A38 Derby Junctions
TR010022
8.15(b) Statement of Common Ground
with
McDonald's

**Statement of Common Ground
McDonald's**

| Version | Date | Status of Version |
|----------------|--------------|--------------------------|
| Final | 18 June 2020 | Deadline 14 Submission |

CUSTOMER TRACKS

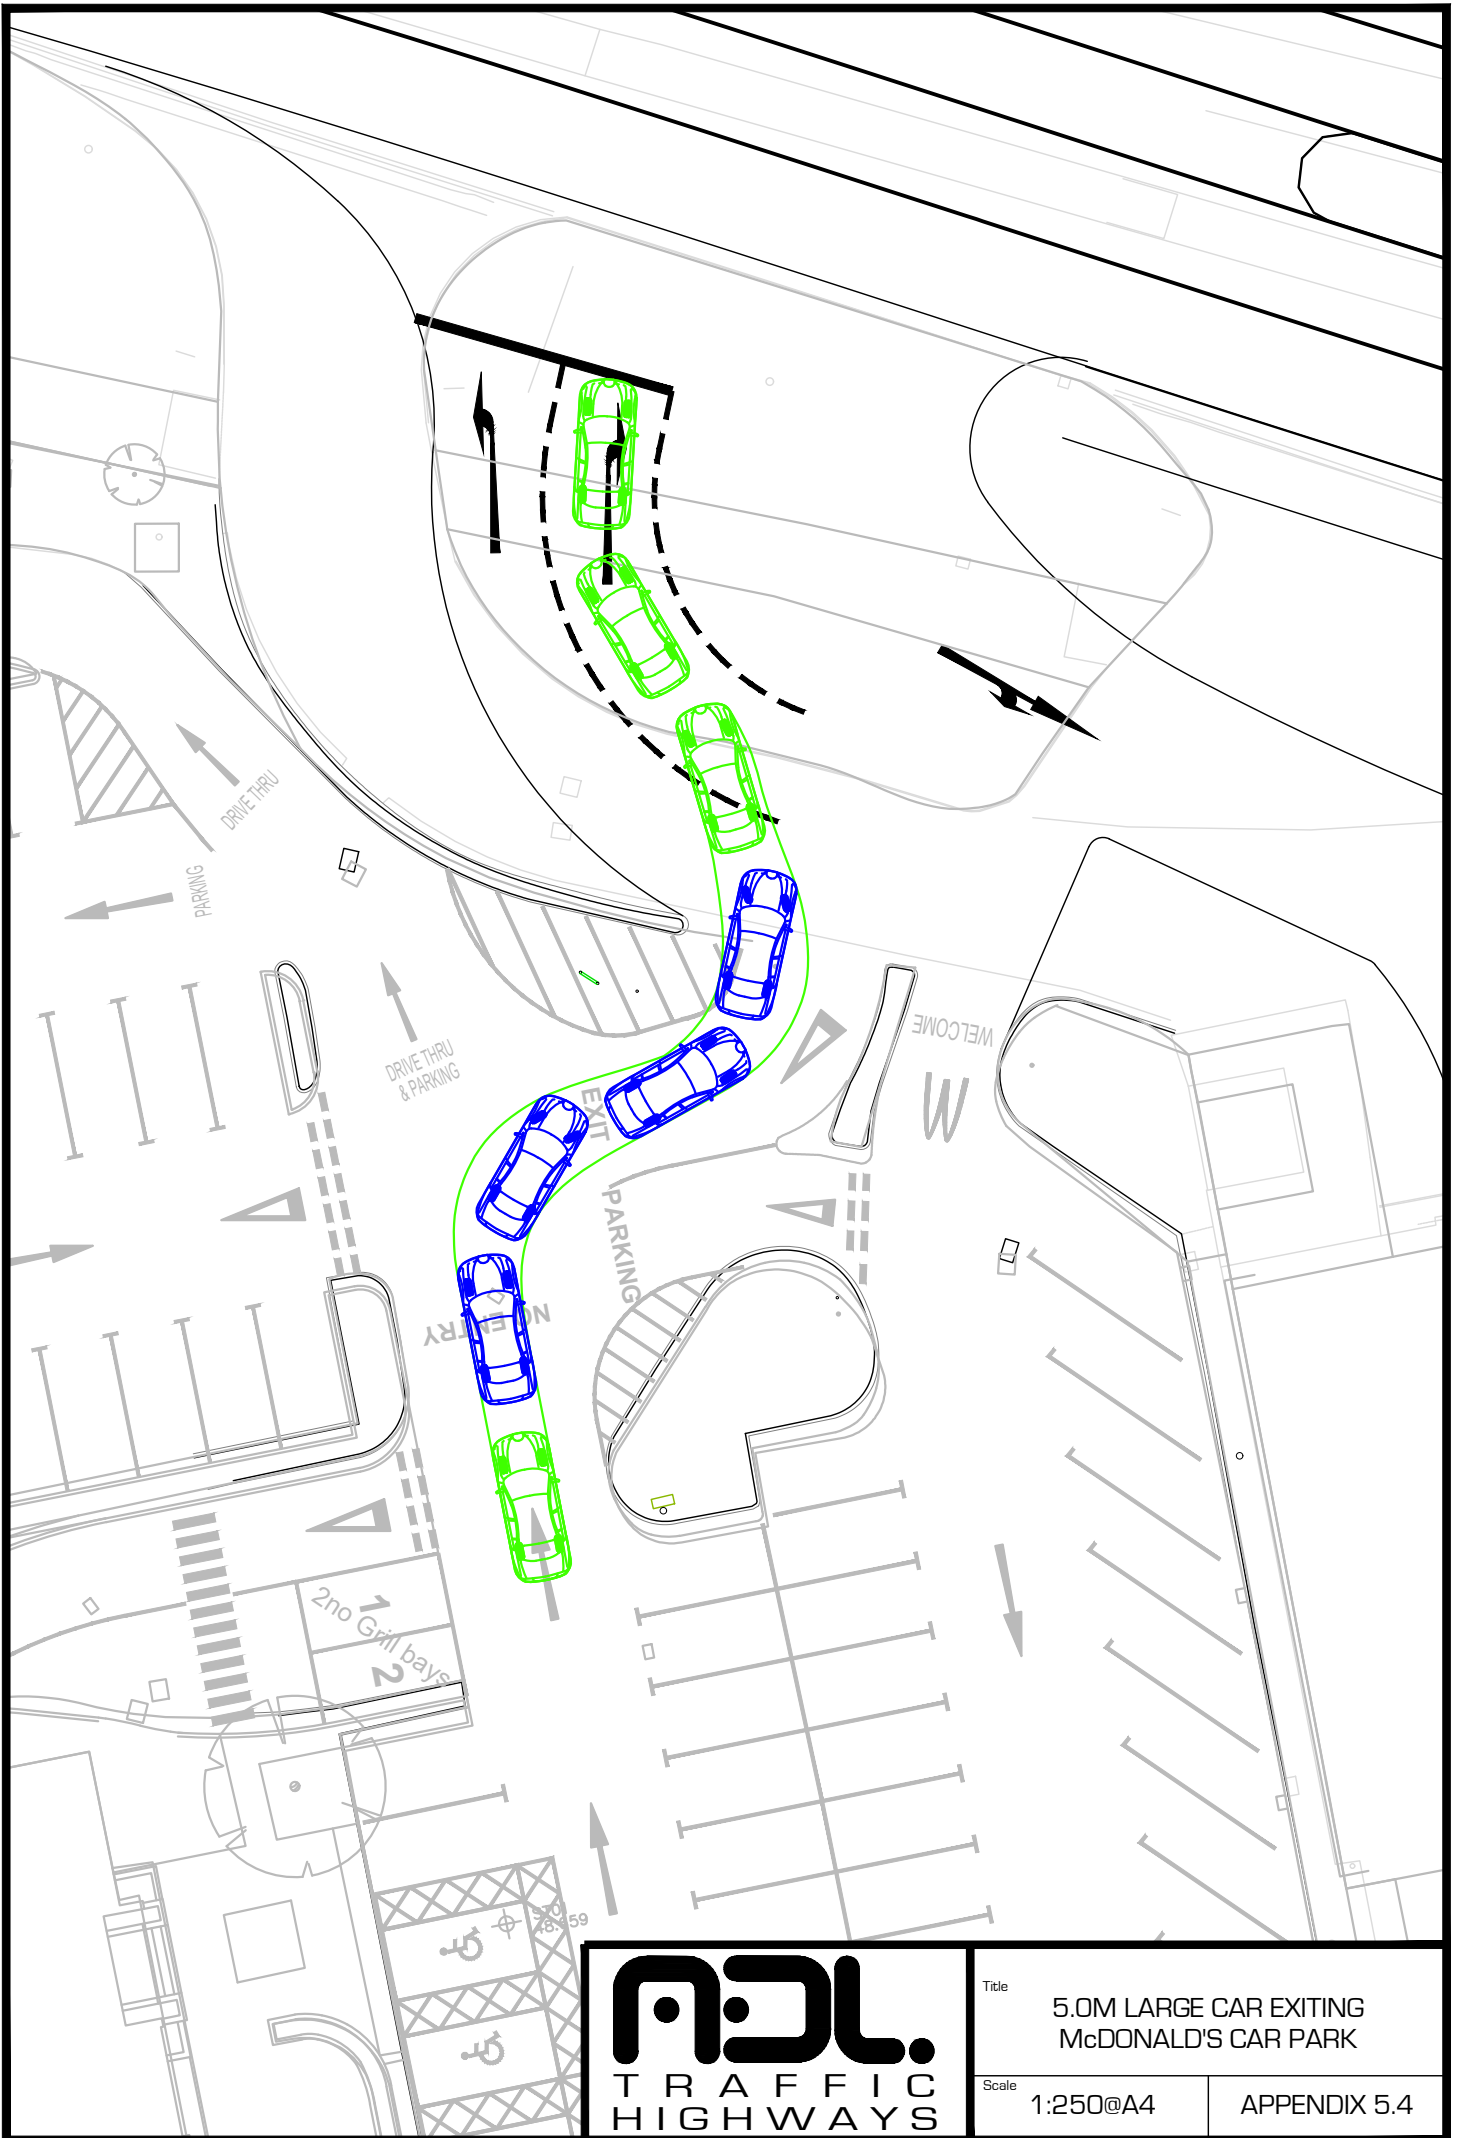
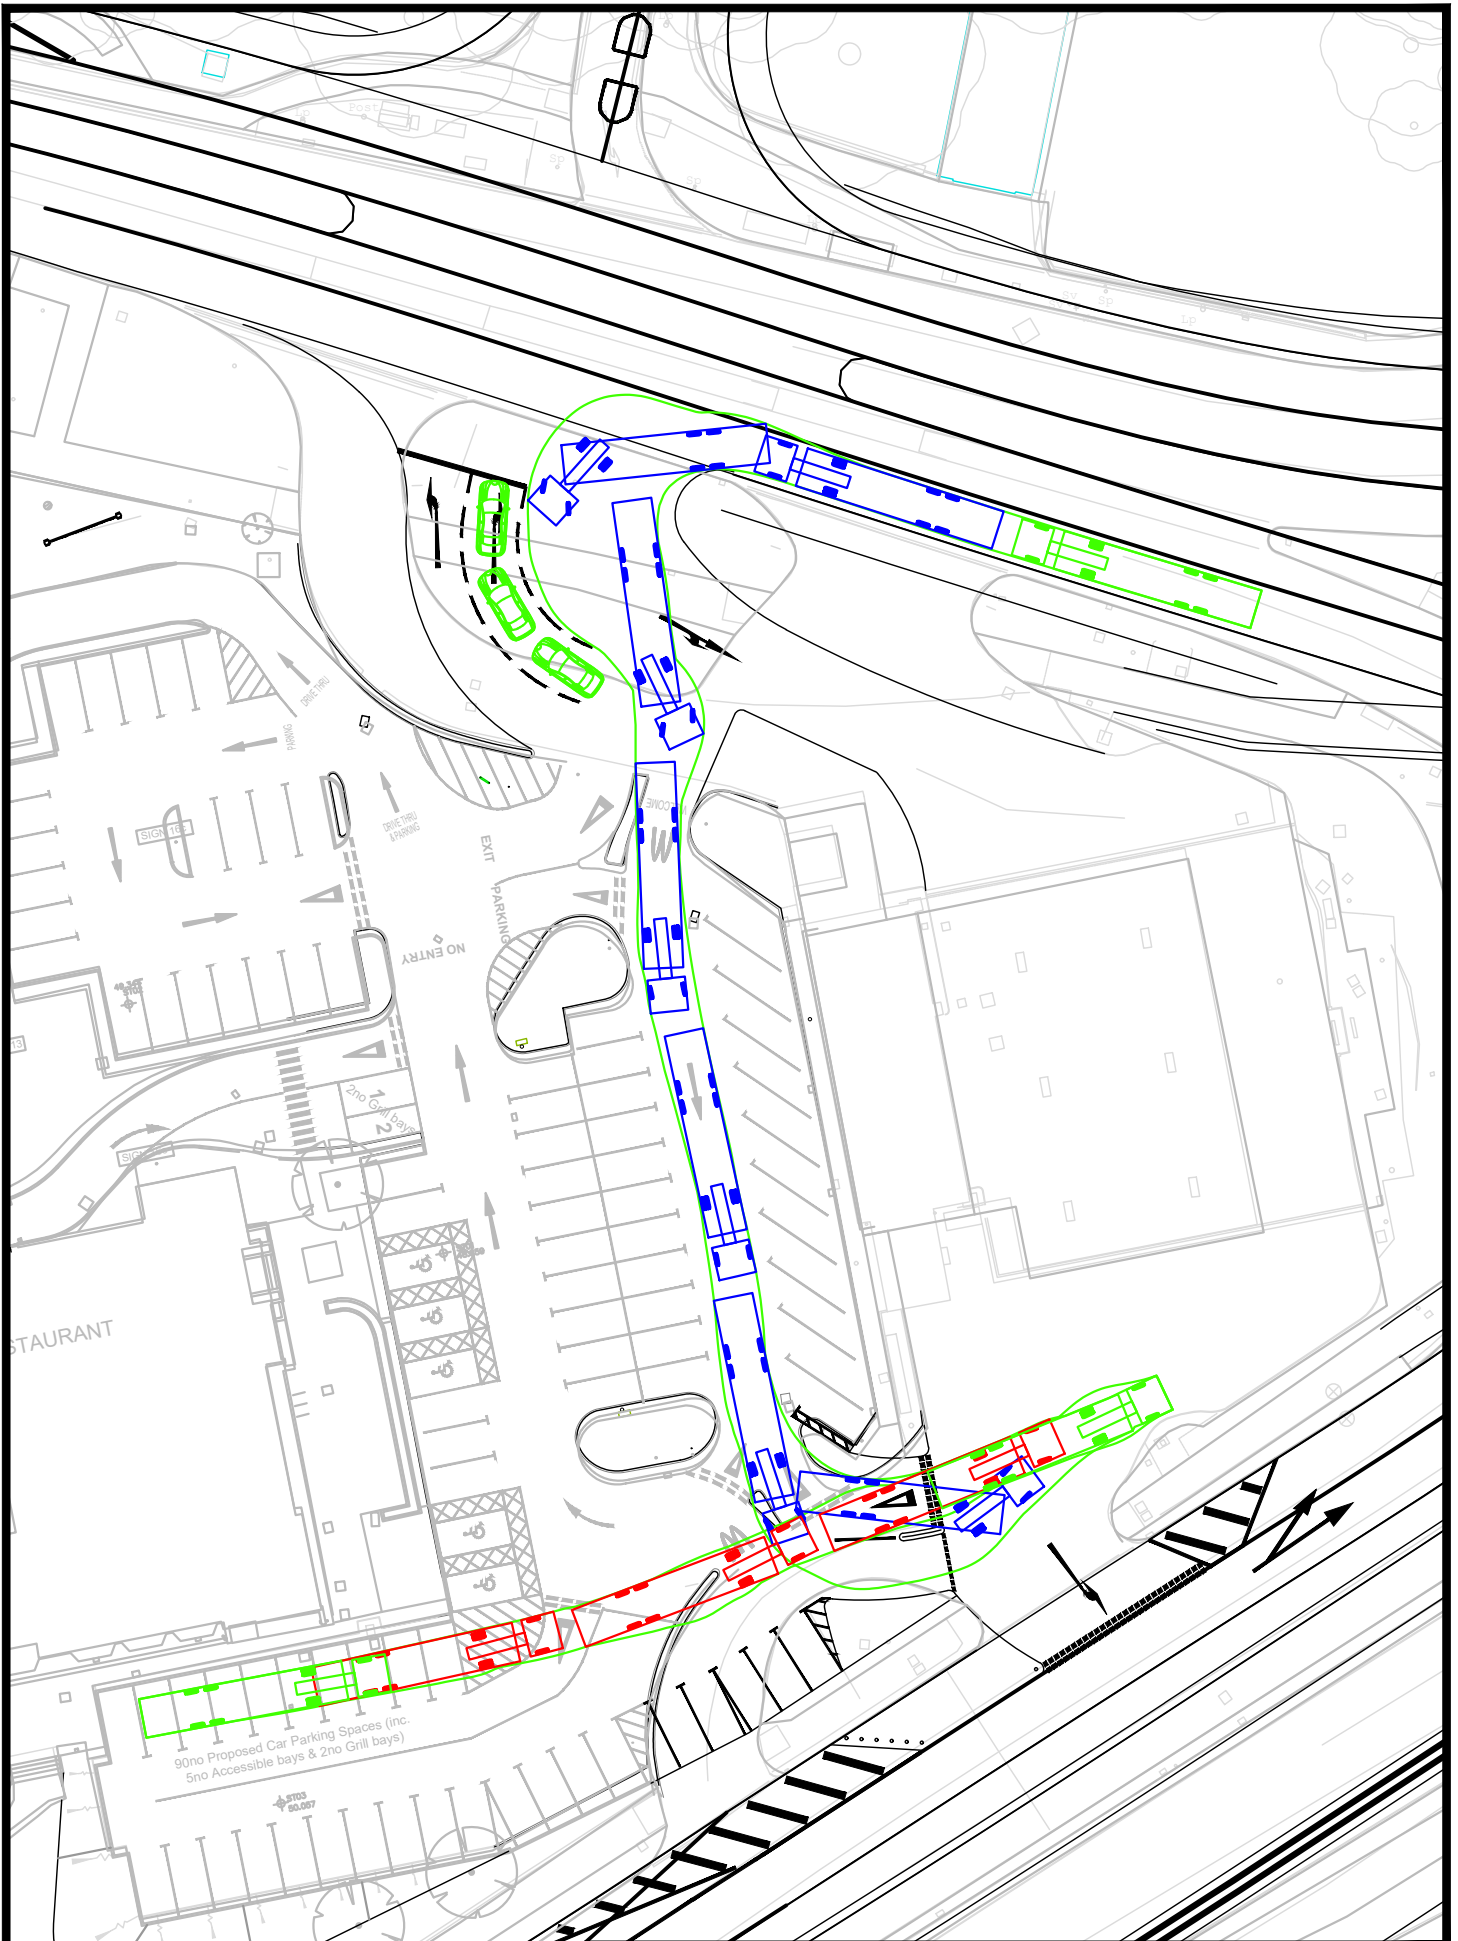
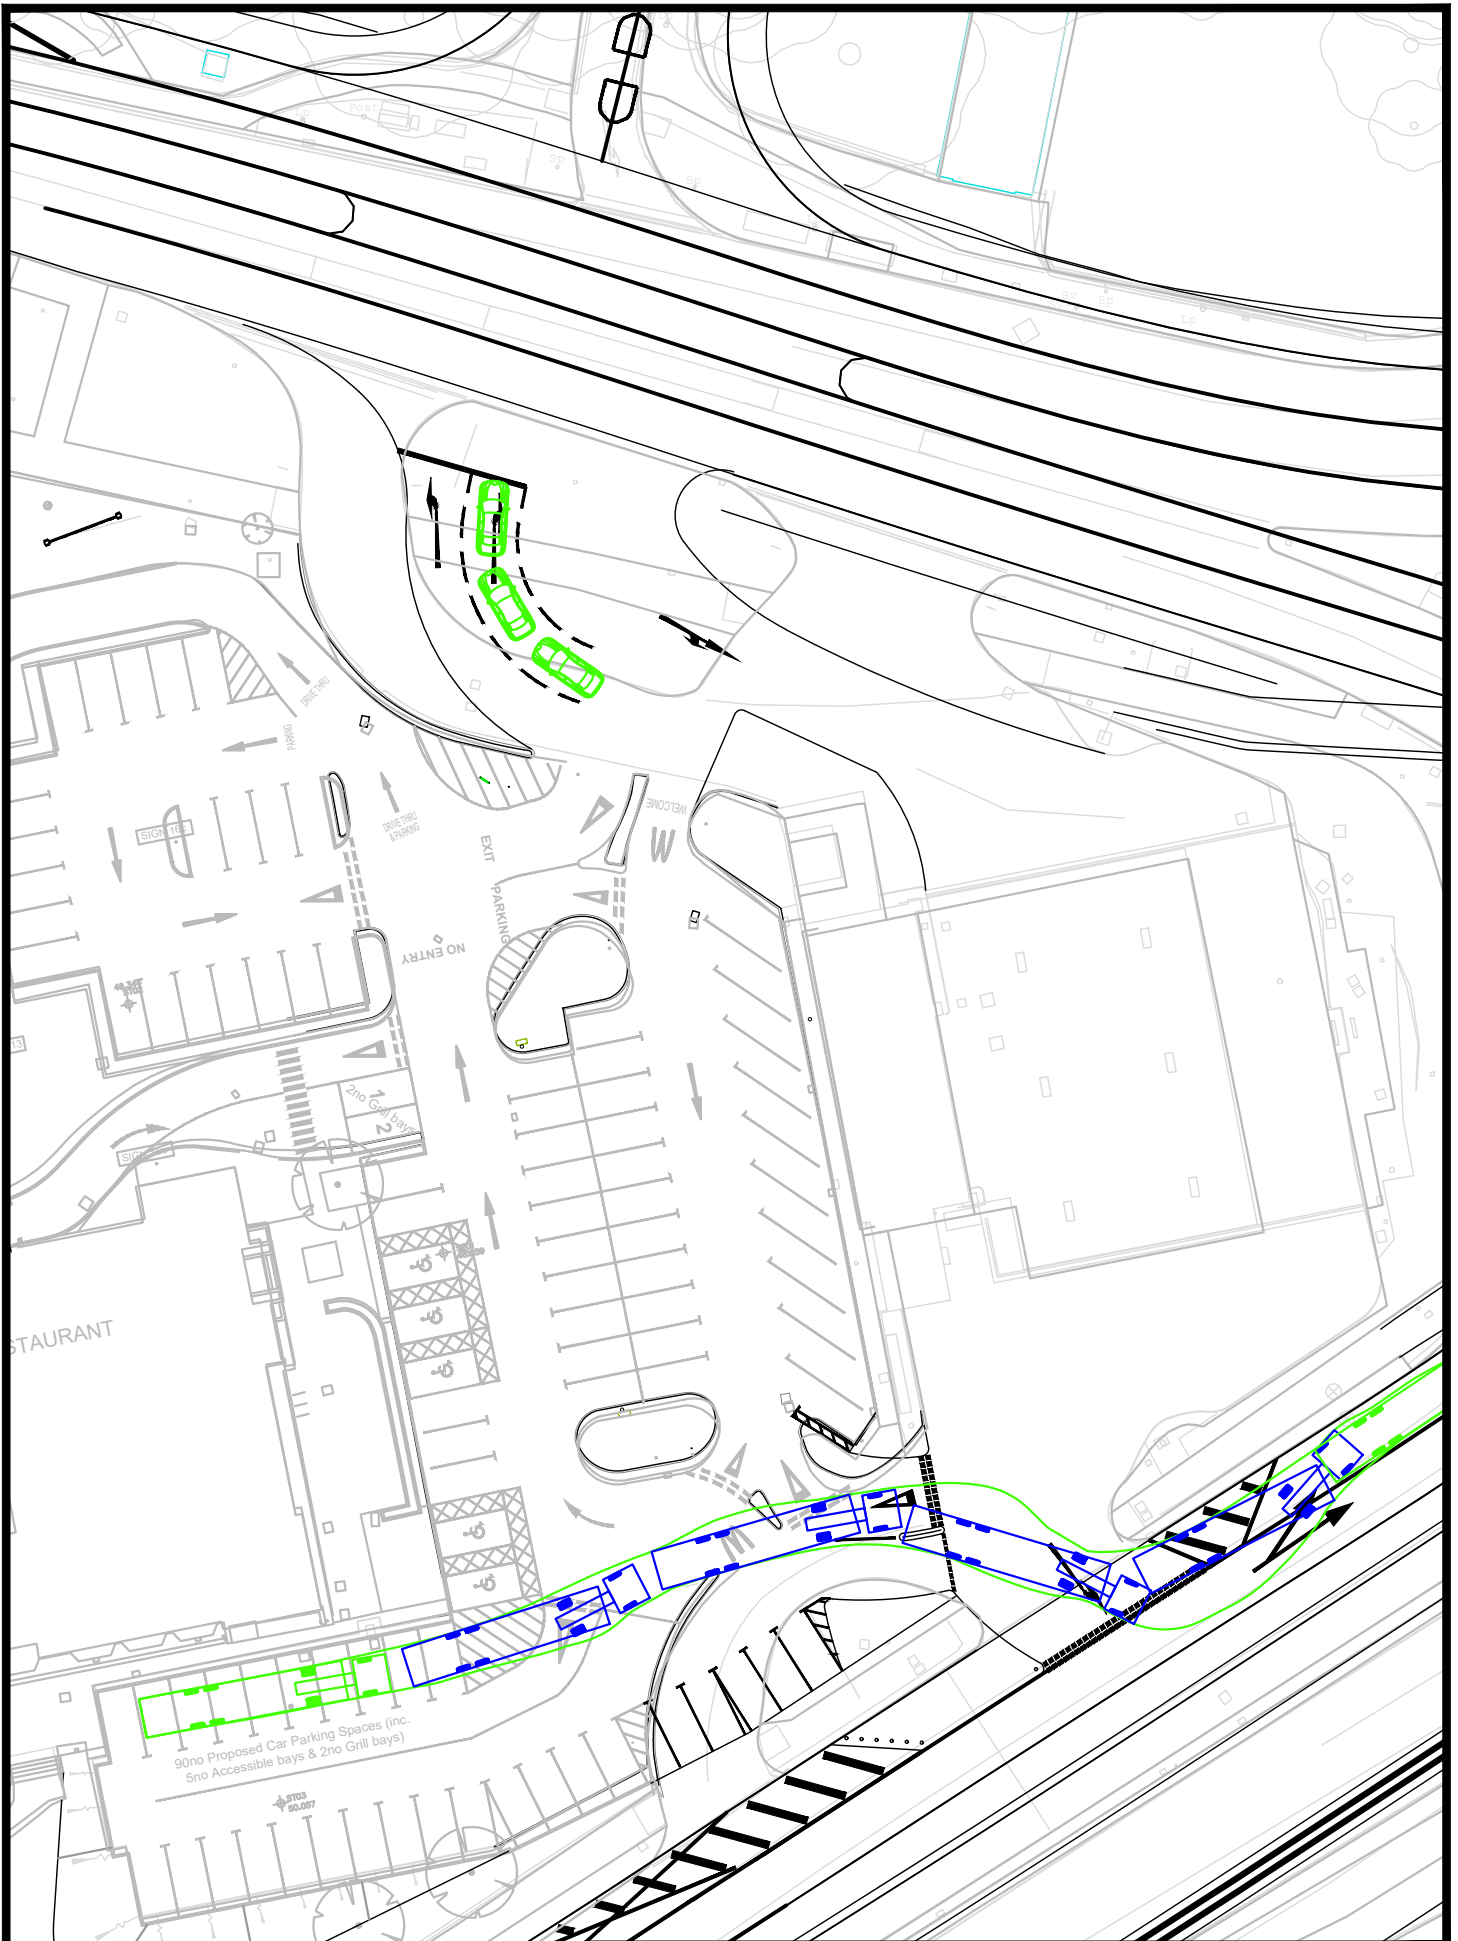
| Issues Reference (see Appendix A) | Document | Paragraph Ref | Sub-section | Comment | Highways England Response | Status |
|--|----------------------------------|---------------|-------------|--|---|------------------|
| Issue ref: I.1, access and potential impacts | Written Representation Comments* | Point 2 | a) | <p>Currently, deliveries to the Property are received five times per week from the A38 entrance. The Works necessitate a change in delivery routes into the restaurant. The proposed route does not account for how McDonald's delivery vehicles manoeuvre around the Property or potential health and safety concerns. Delivery cages weigh hundreds of kilograms and McDonald's car park is reinforced in the south part only. By closing the A38 entrance, delivery vehicles will no longer be able to service the Property; they are too heavy to safely cross the unreinforced north section of the Property.</p> | <p>Swept path diagrams have been provided to demonstrate that access for deliveries from the proposed new A52 access is feasible within the current car park layout (and crossing onto the Euro Garages land as they do at present).</p> <p>Highways England has advised that, during the detailed design stage, pavement surveys could be carried out to determine the strength of all parts of the car park – strengthening could be carried out as accommodation works if required.</p> <p>Highways England would welcome details of the existing car park construction (strengthened area and non-strengthened area) if available to be able to assess the load bearing capability.</p> <p>At the meeting on the 15th of January 2020, McDonald's noted that they have committed to taking core samples in</p> | Under discussion |

| Issues Reference (see Appendix A) | Document | Paragraph Ref | Sub-section | Comment | Highways England Response | Status |
|-----------------------------------|----------------------------------|---------------|-------------|--|--|--------|
| Issue ref: I.1, access and safety | Written Representation Comments* | Point 2 | b) | Servicing via Enfield Road (if this remains open) is not appropriate since it is unsafe for heavy trolleys to pass across a non-flat route. There are also practical concerns relating to the safe operation of large commercial vehicles. | It will not be necessary to consider routing deliveries via Enfield road if the above proposals are accepted. | Agreed |
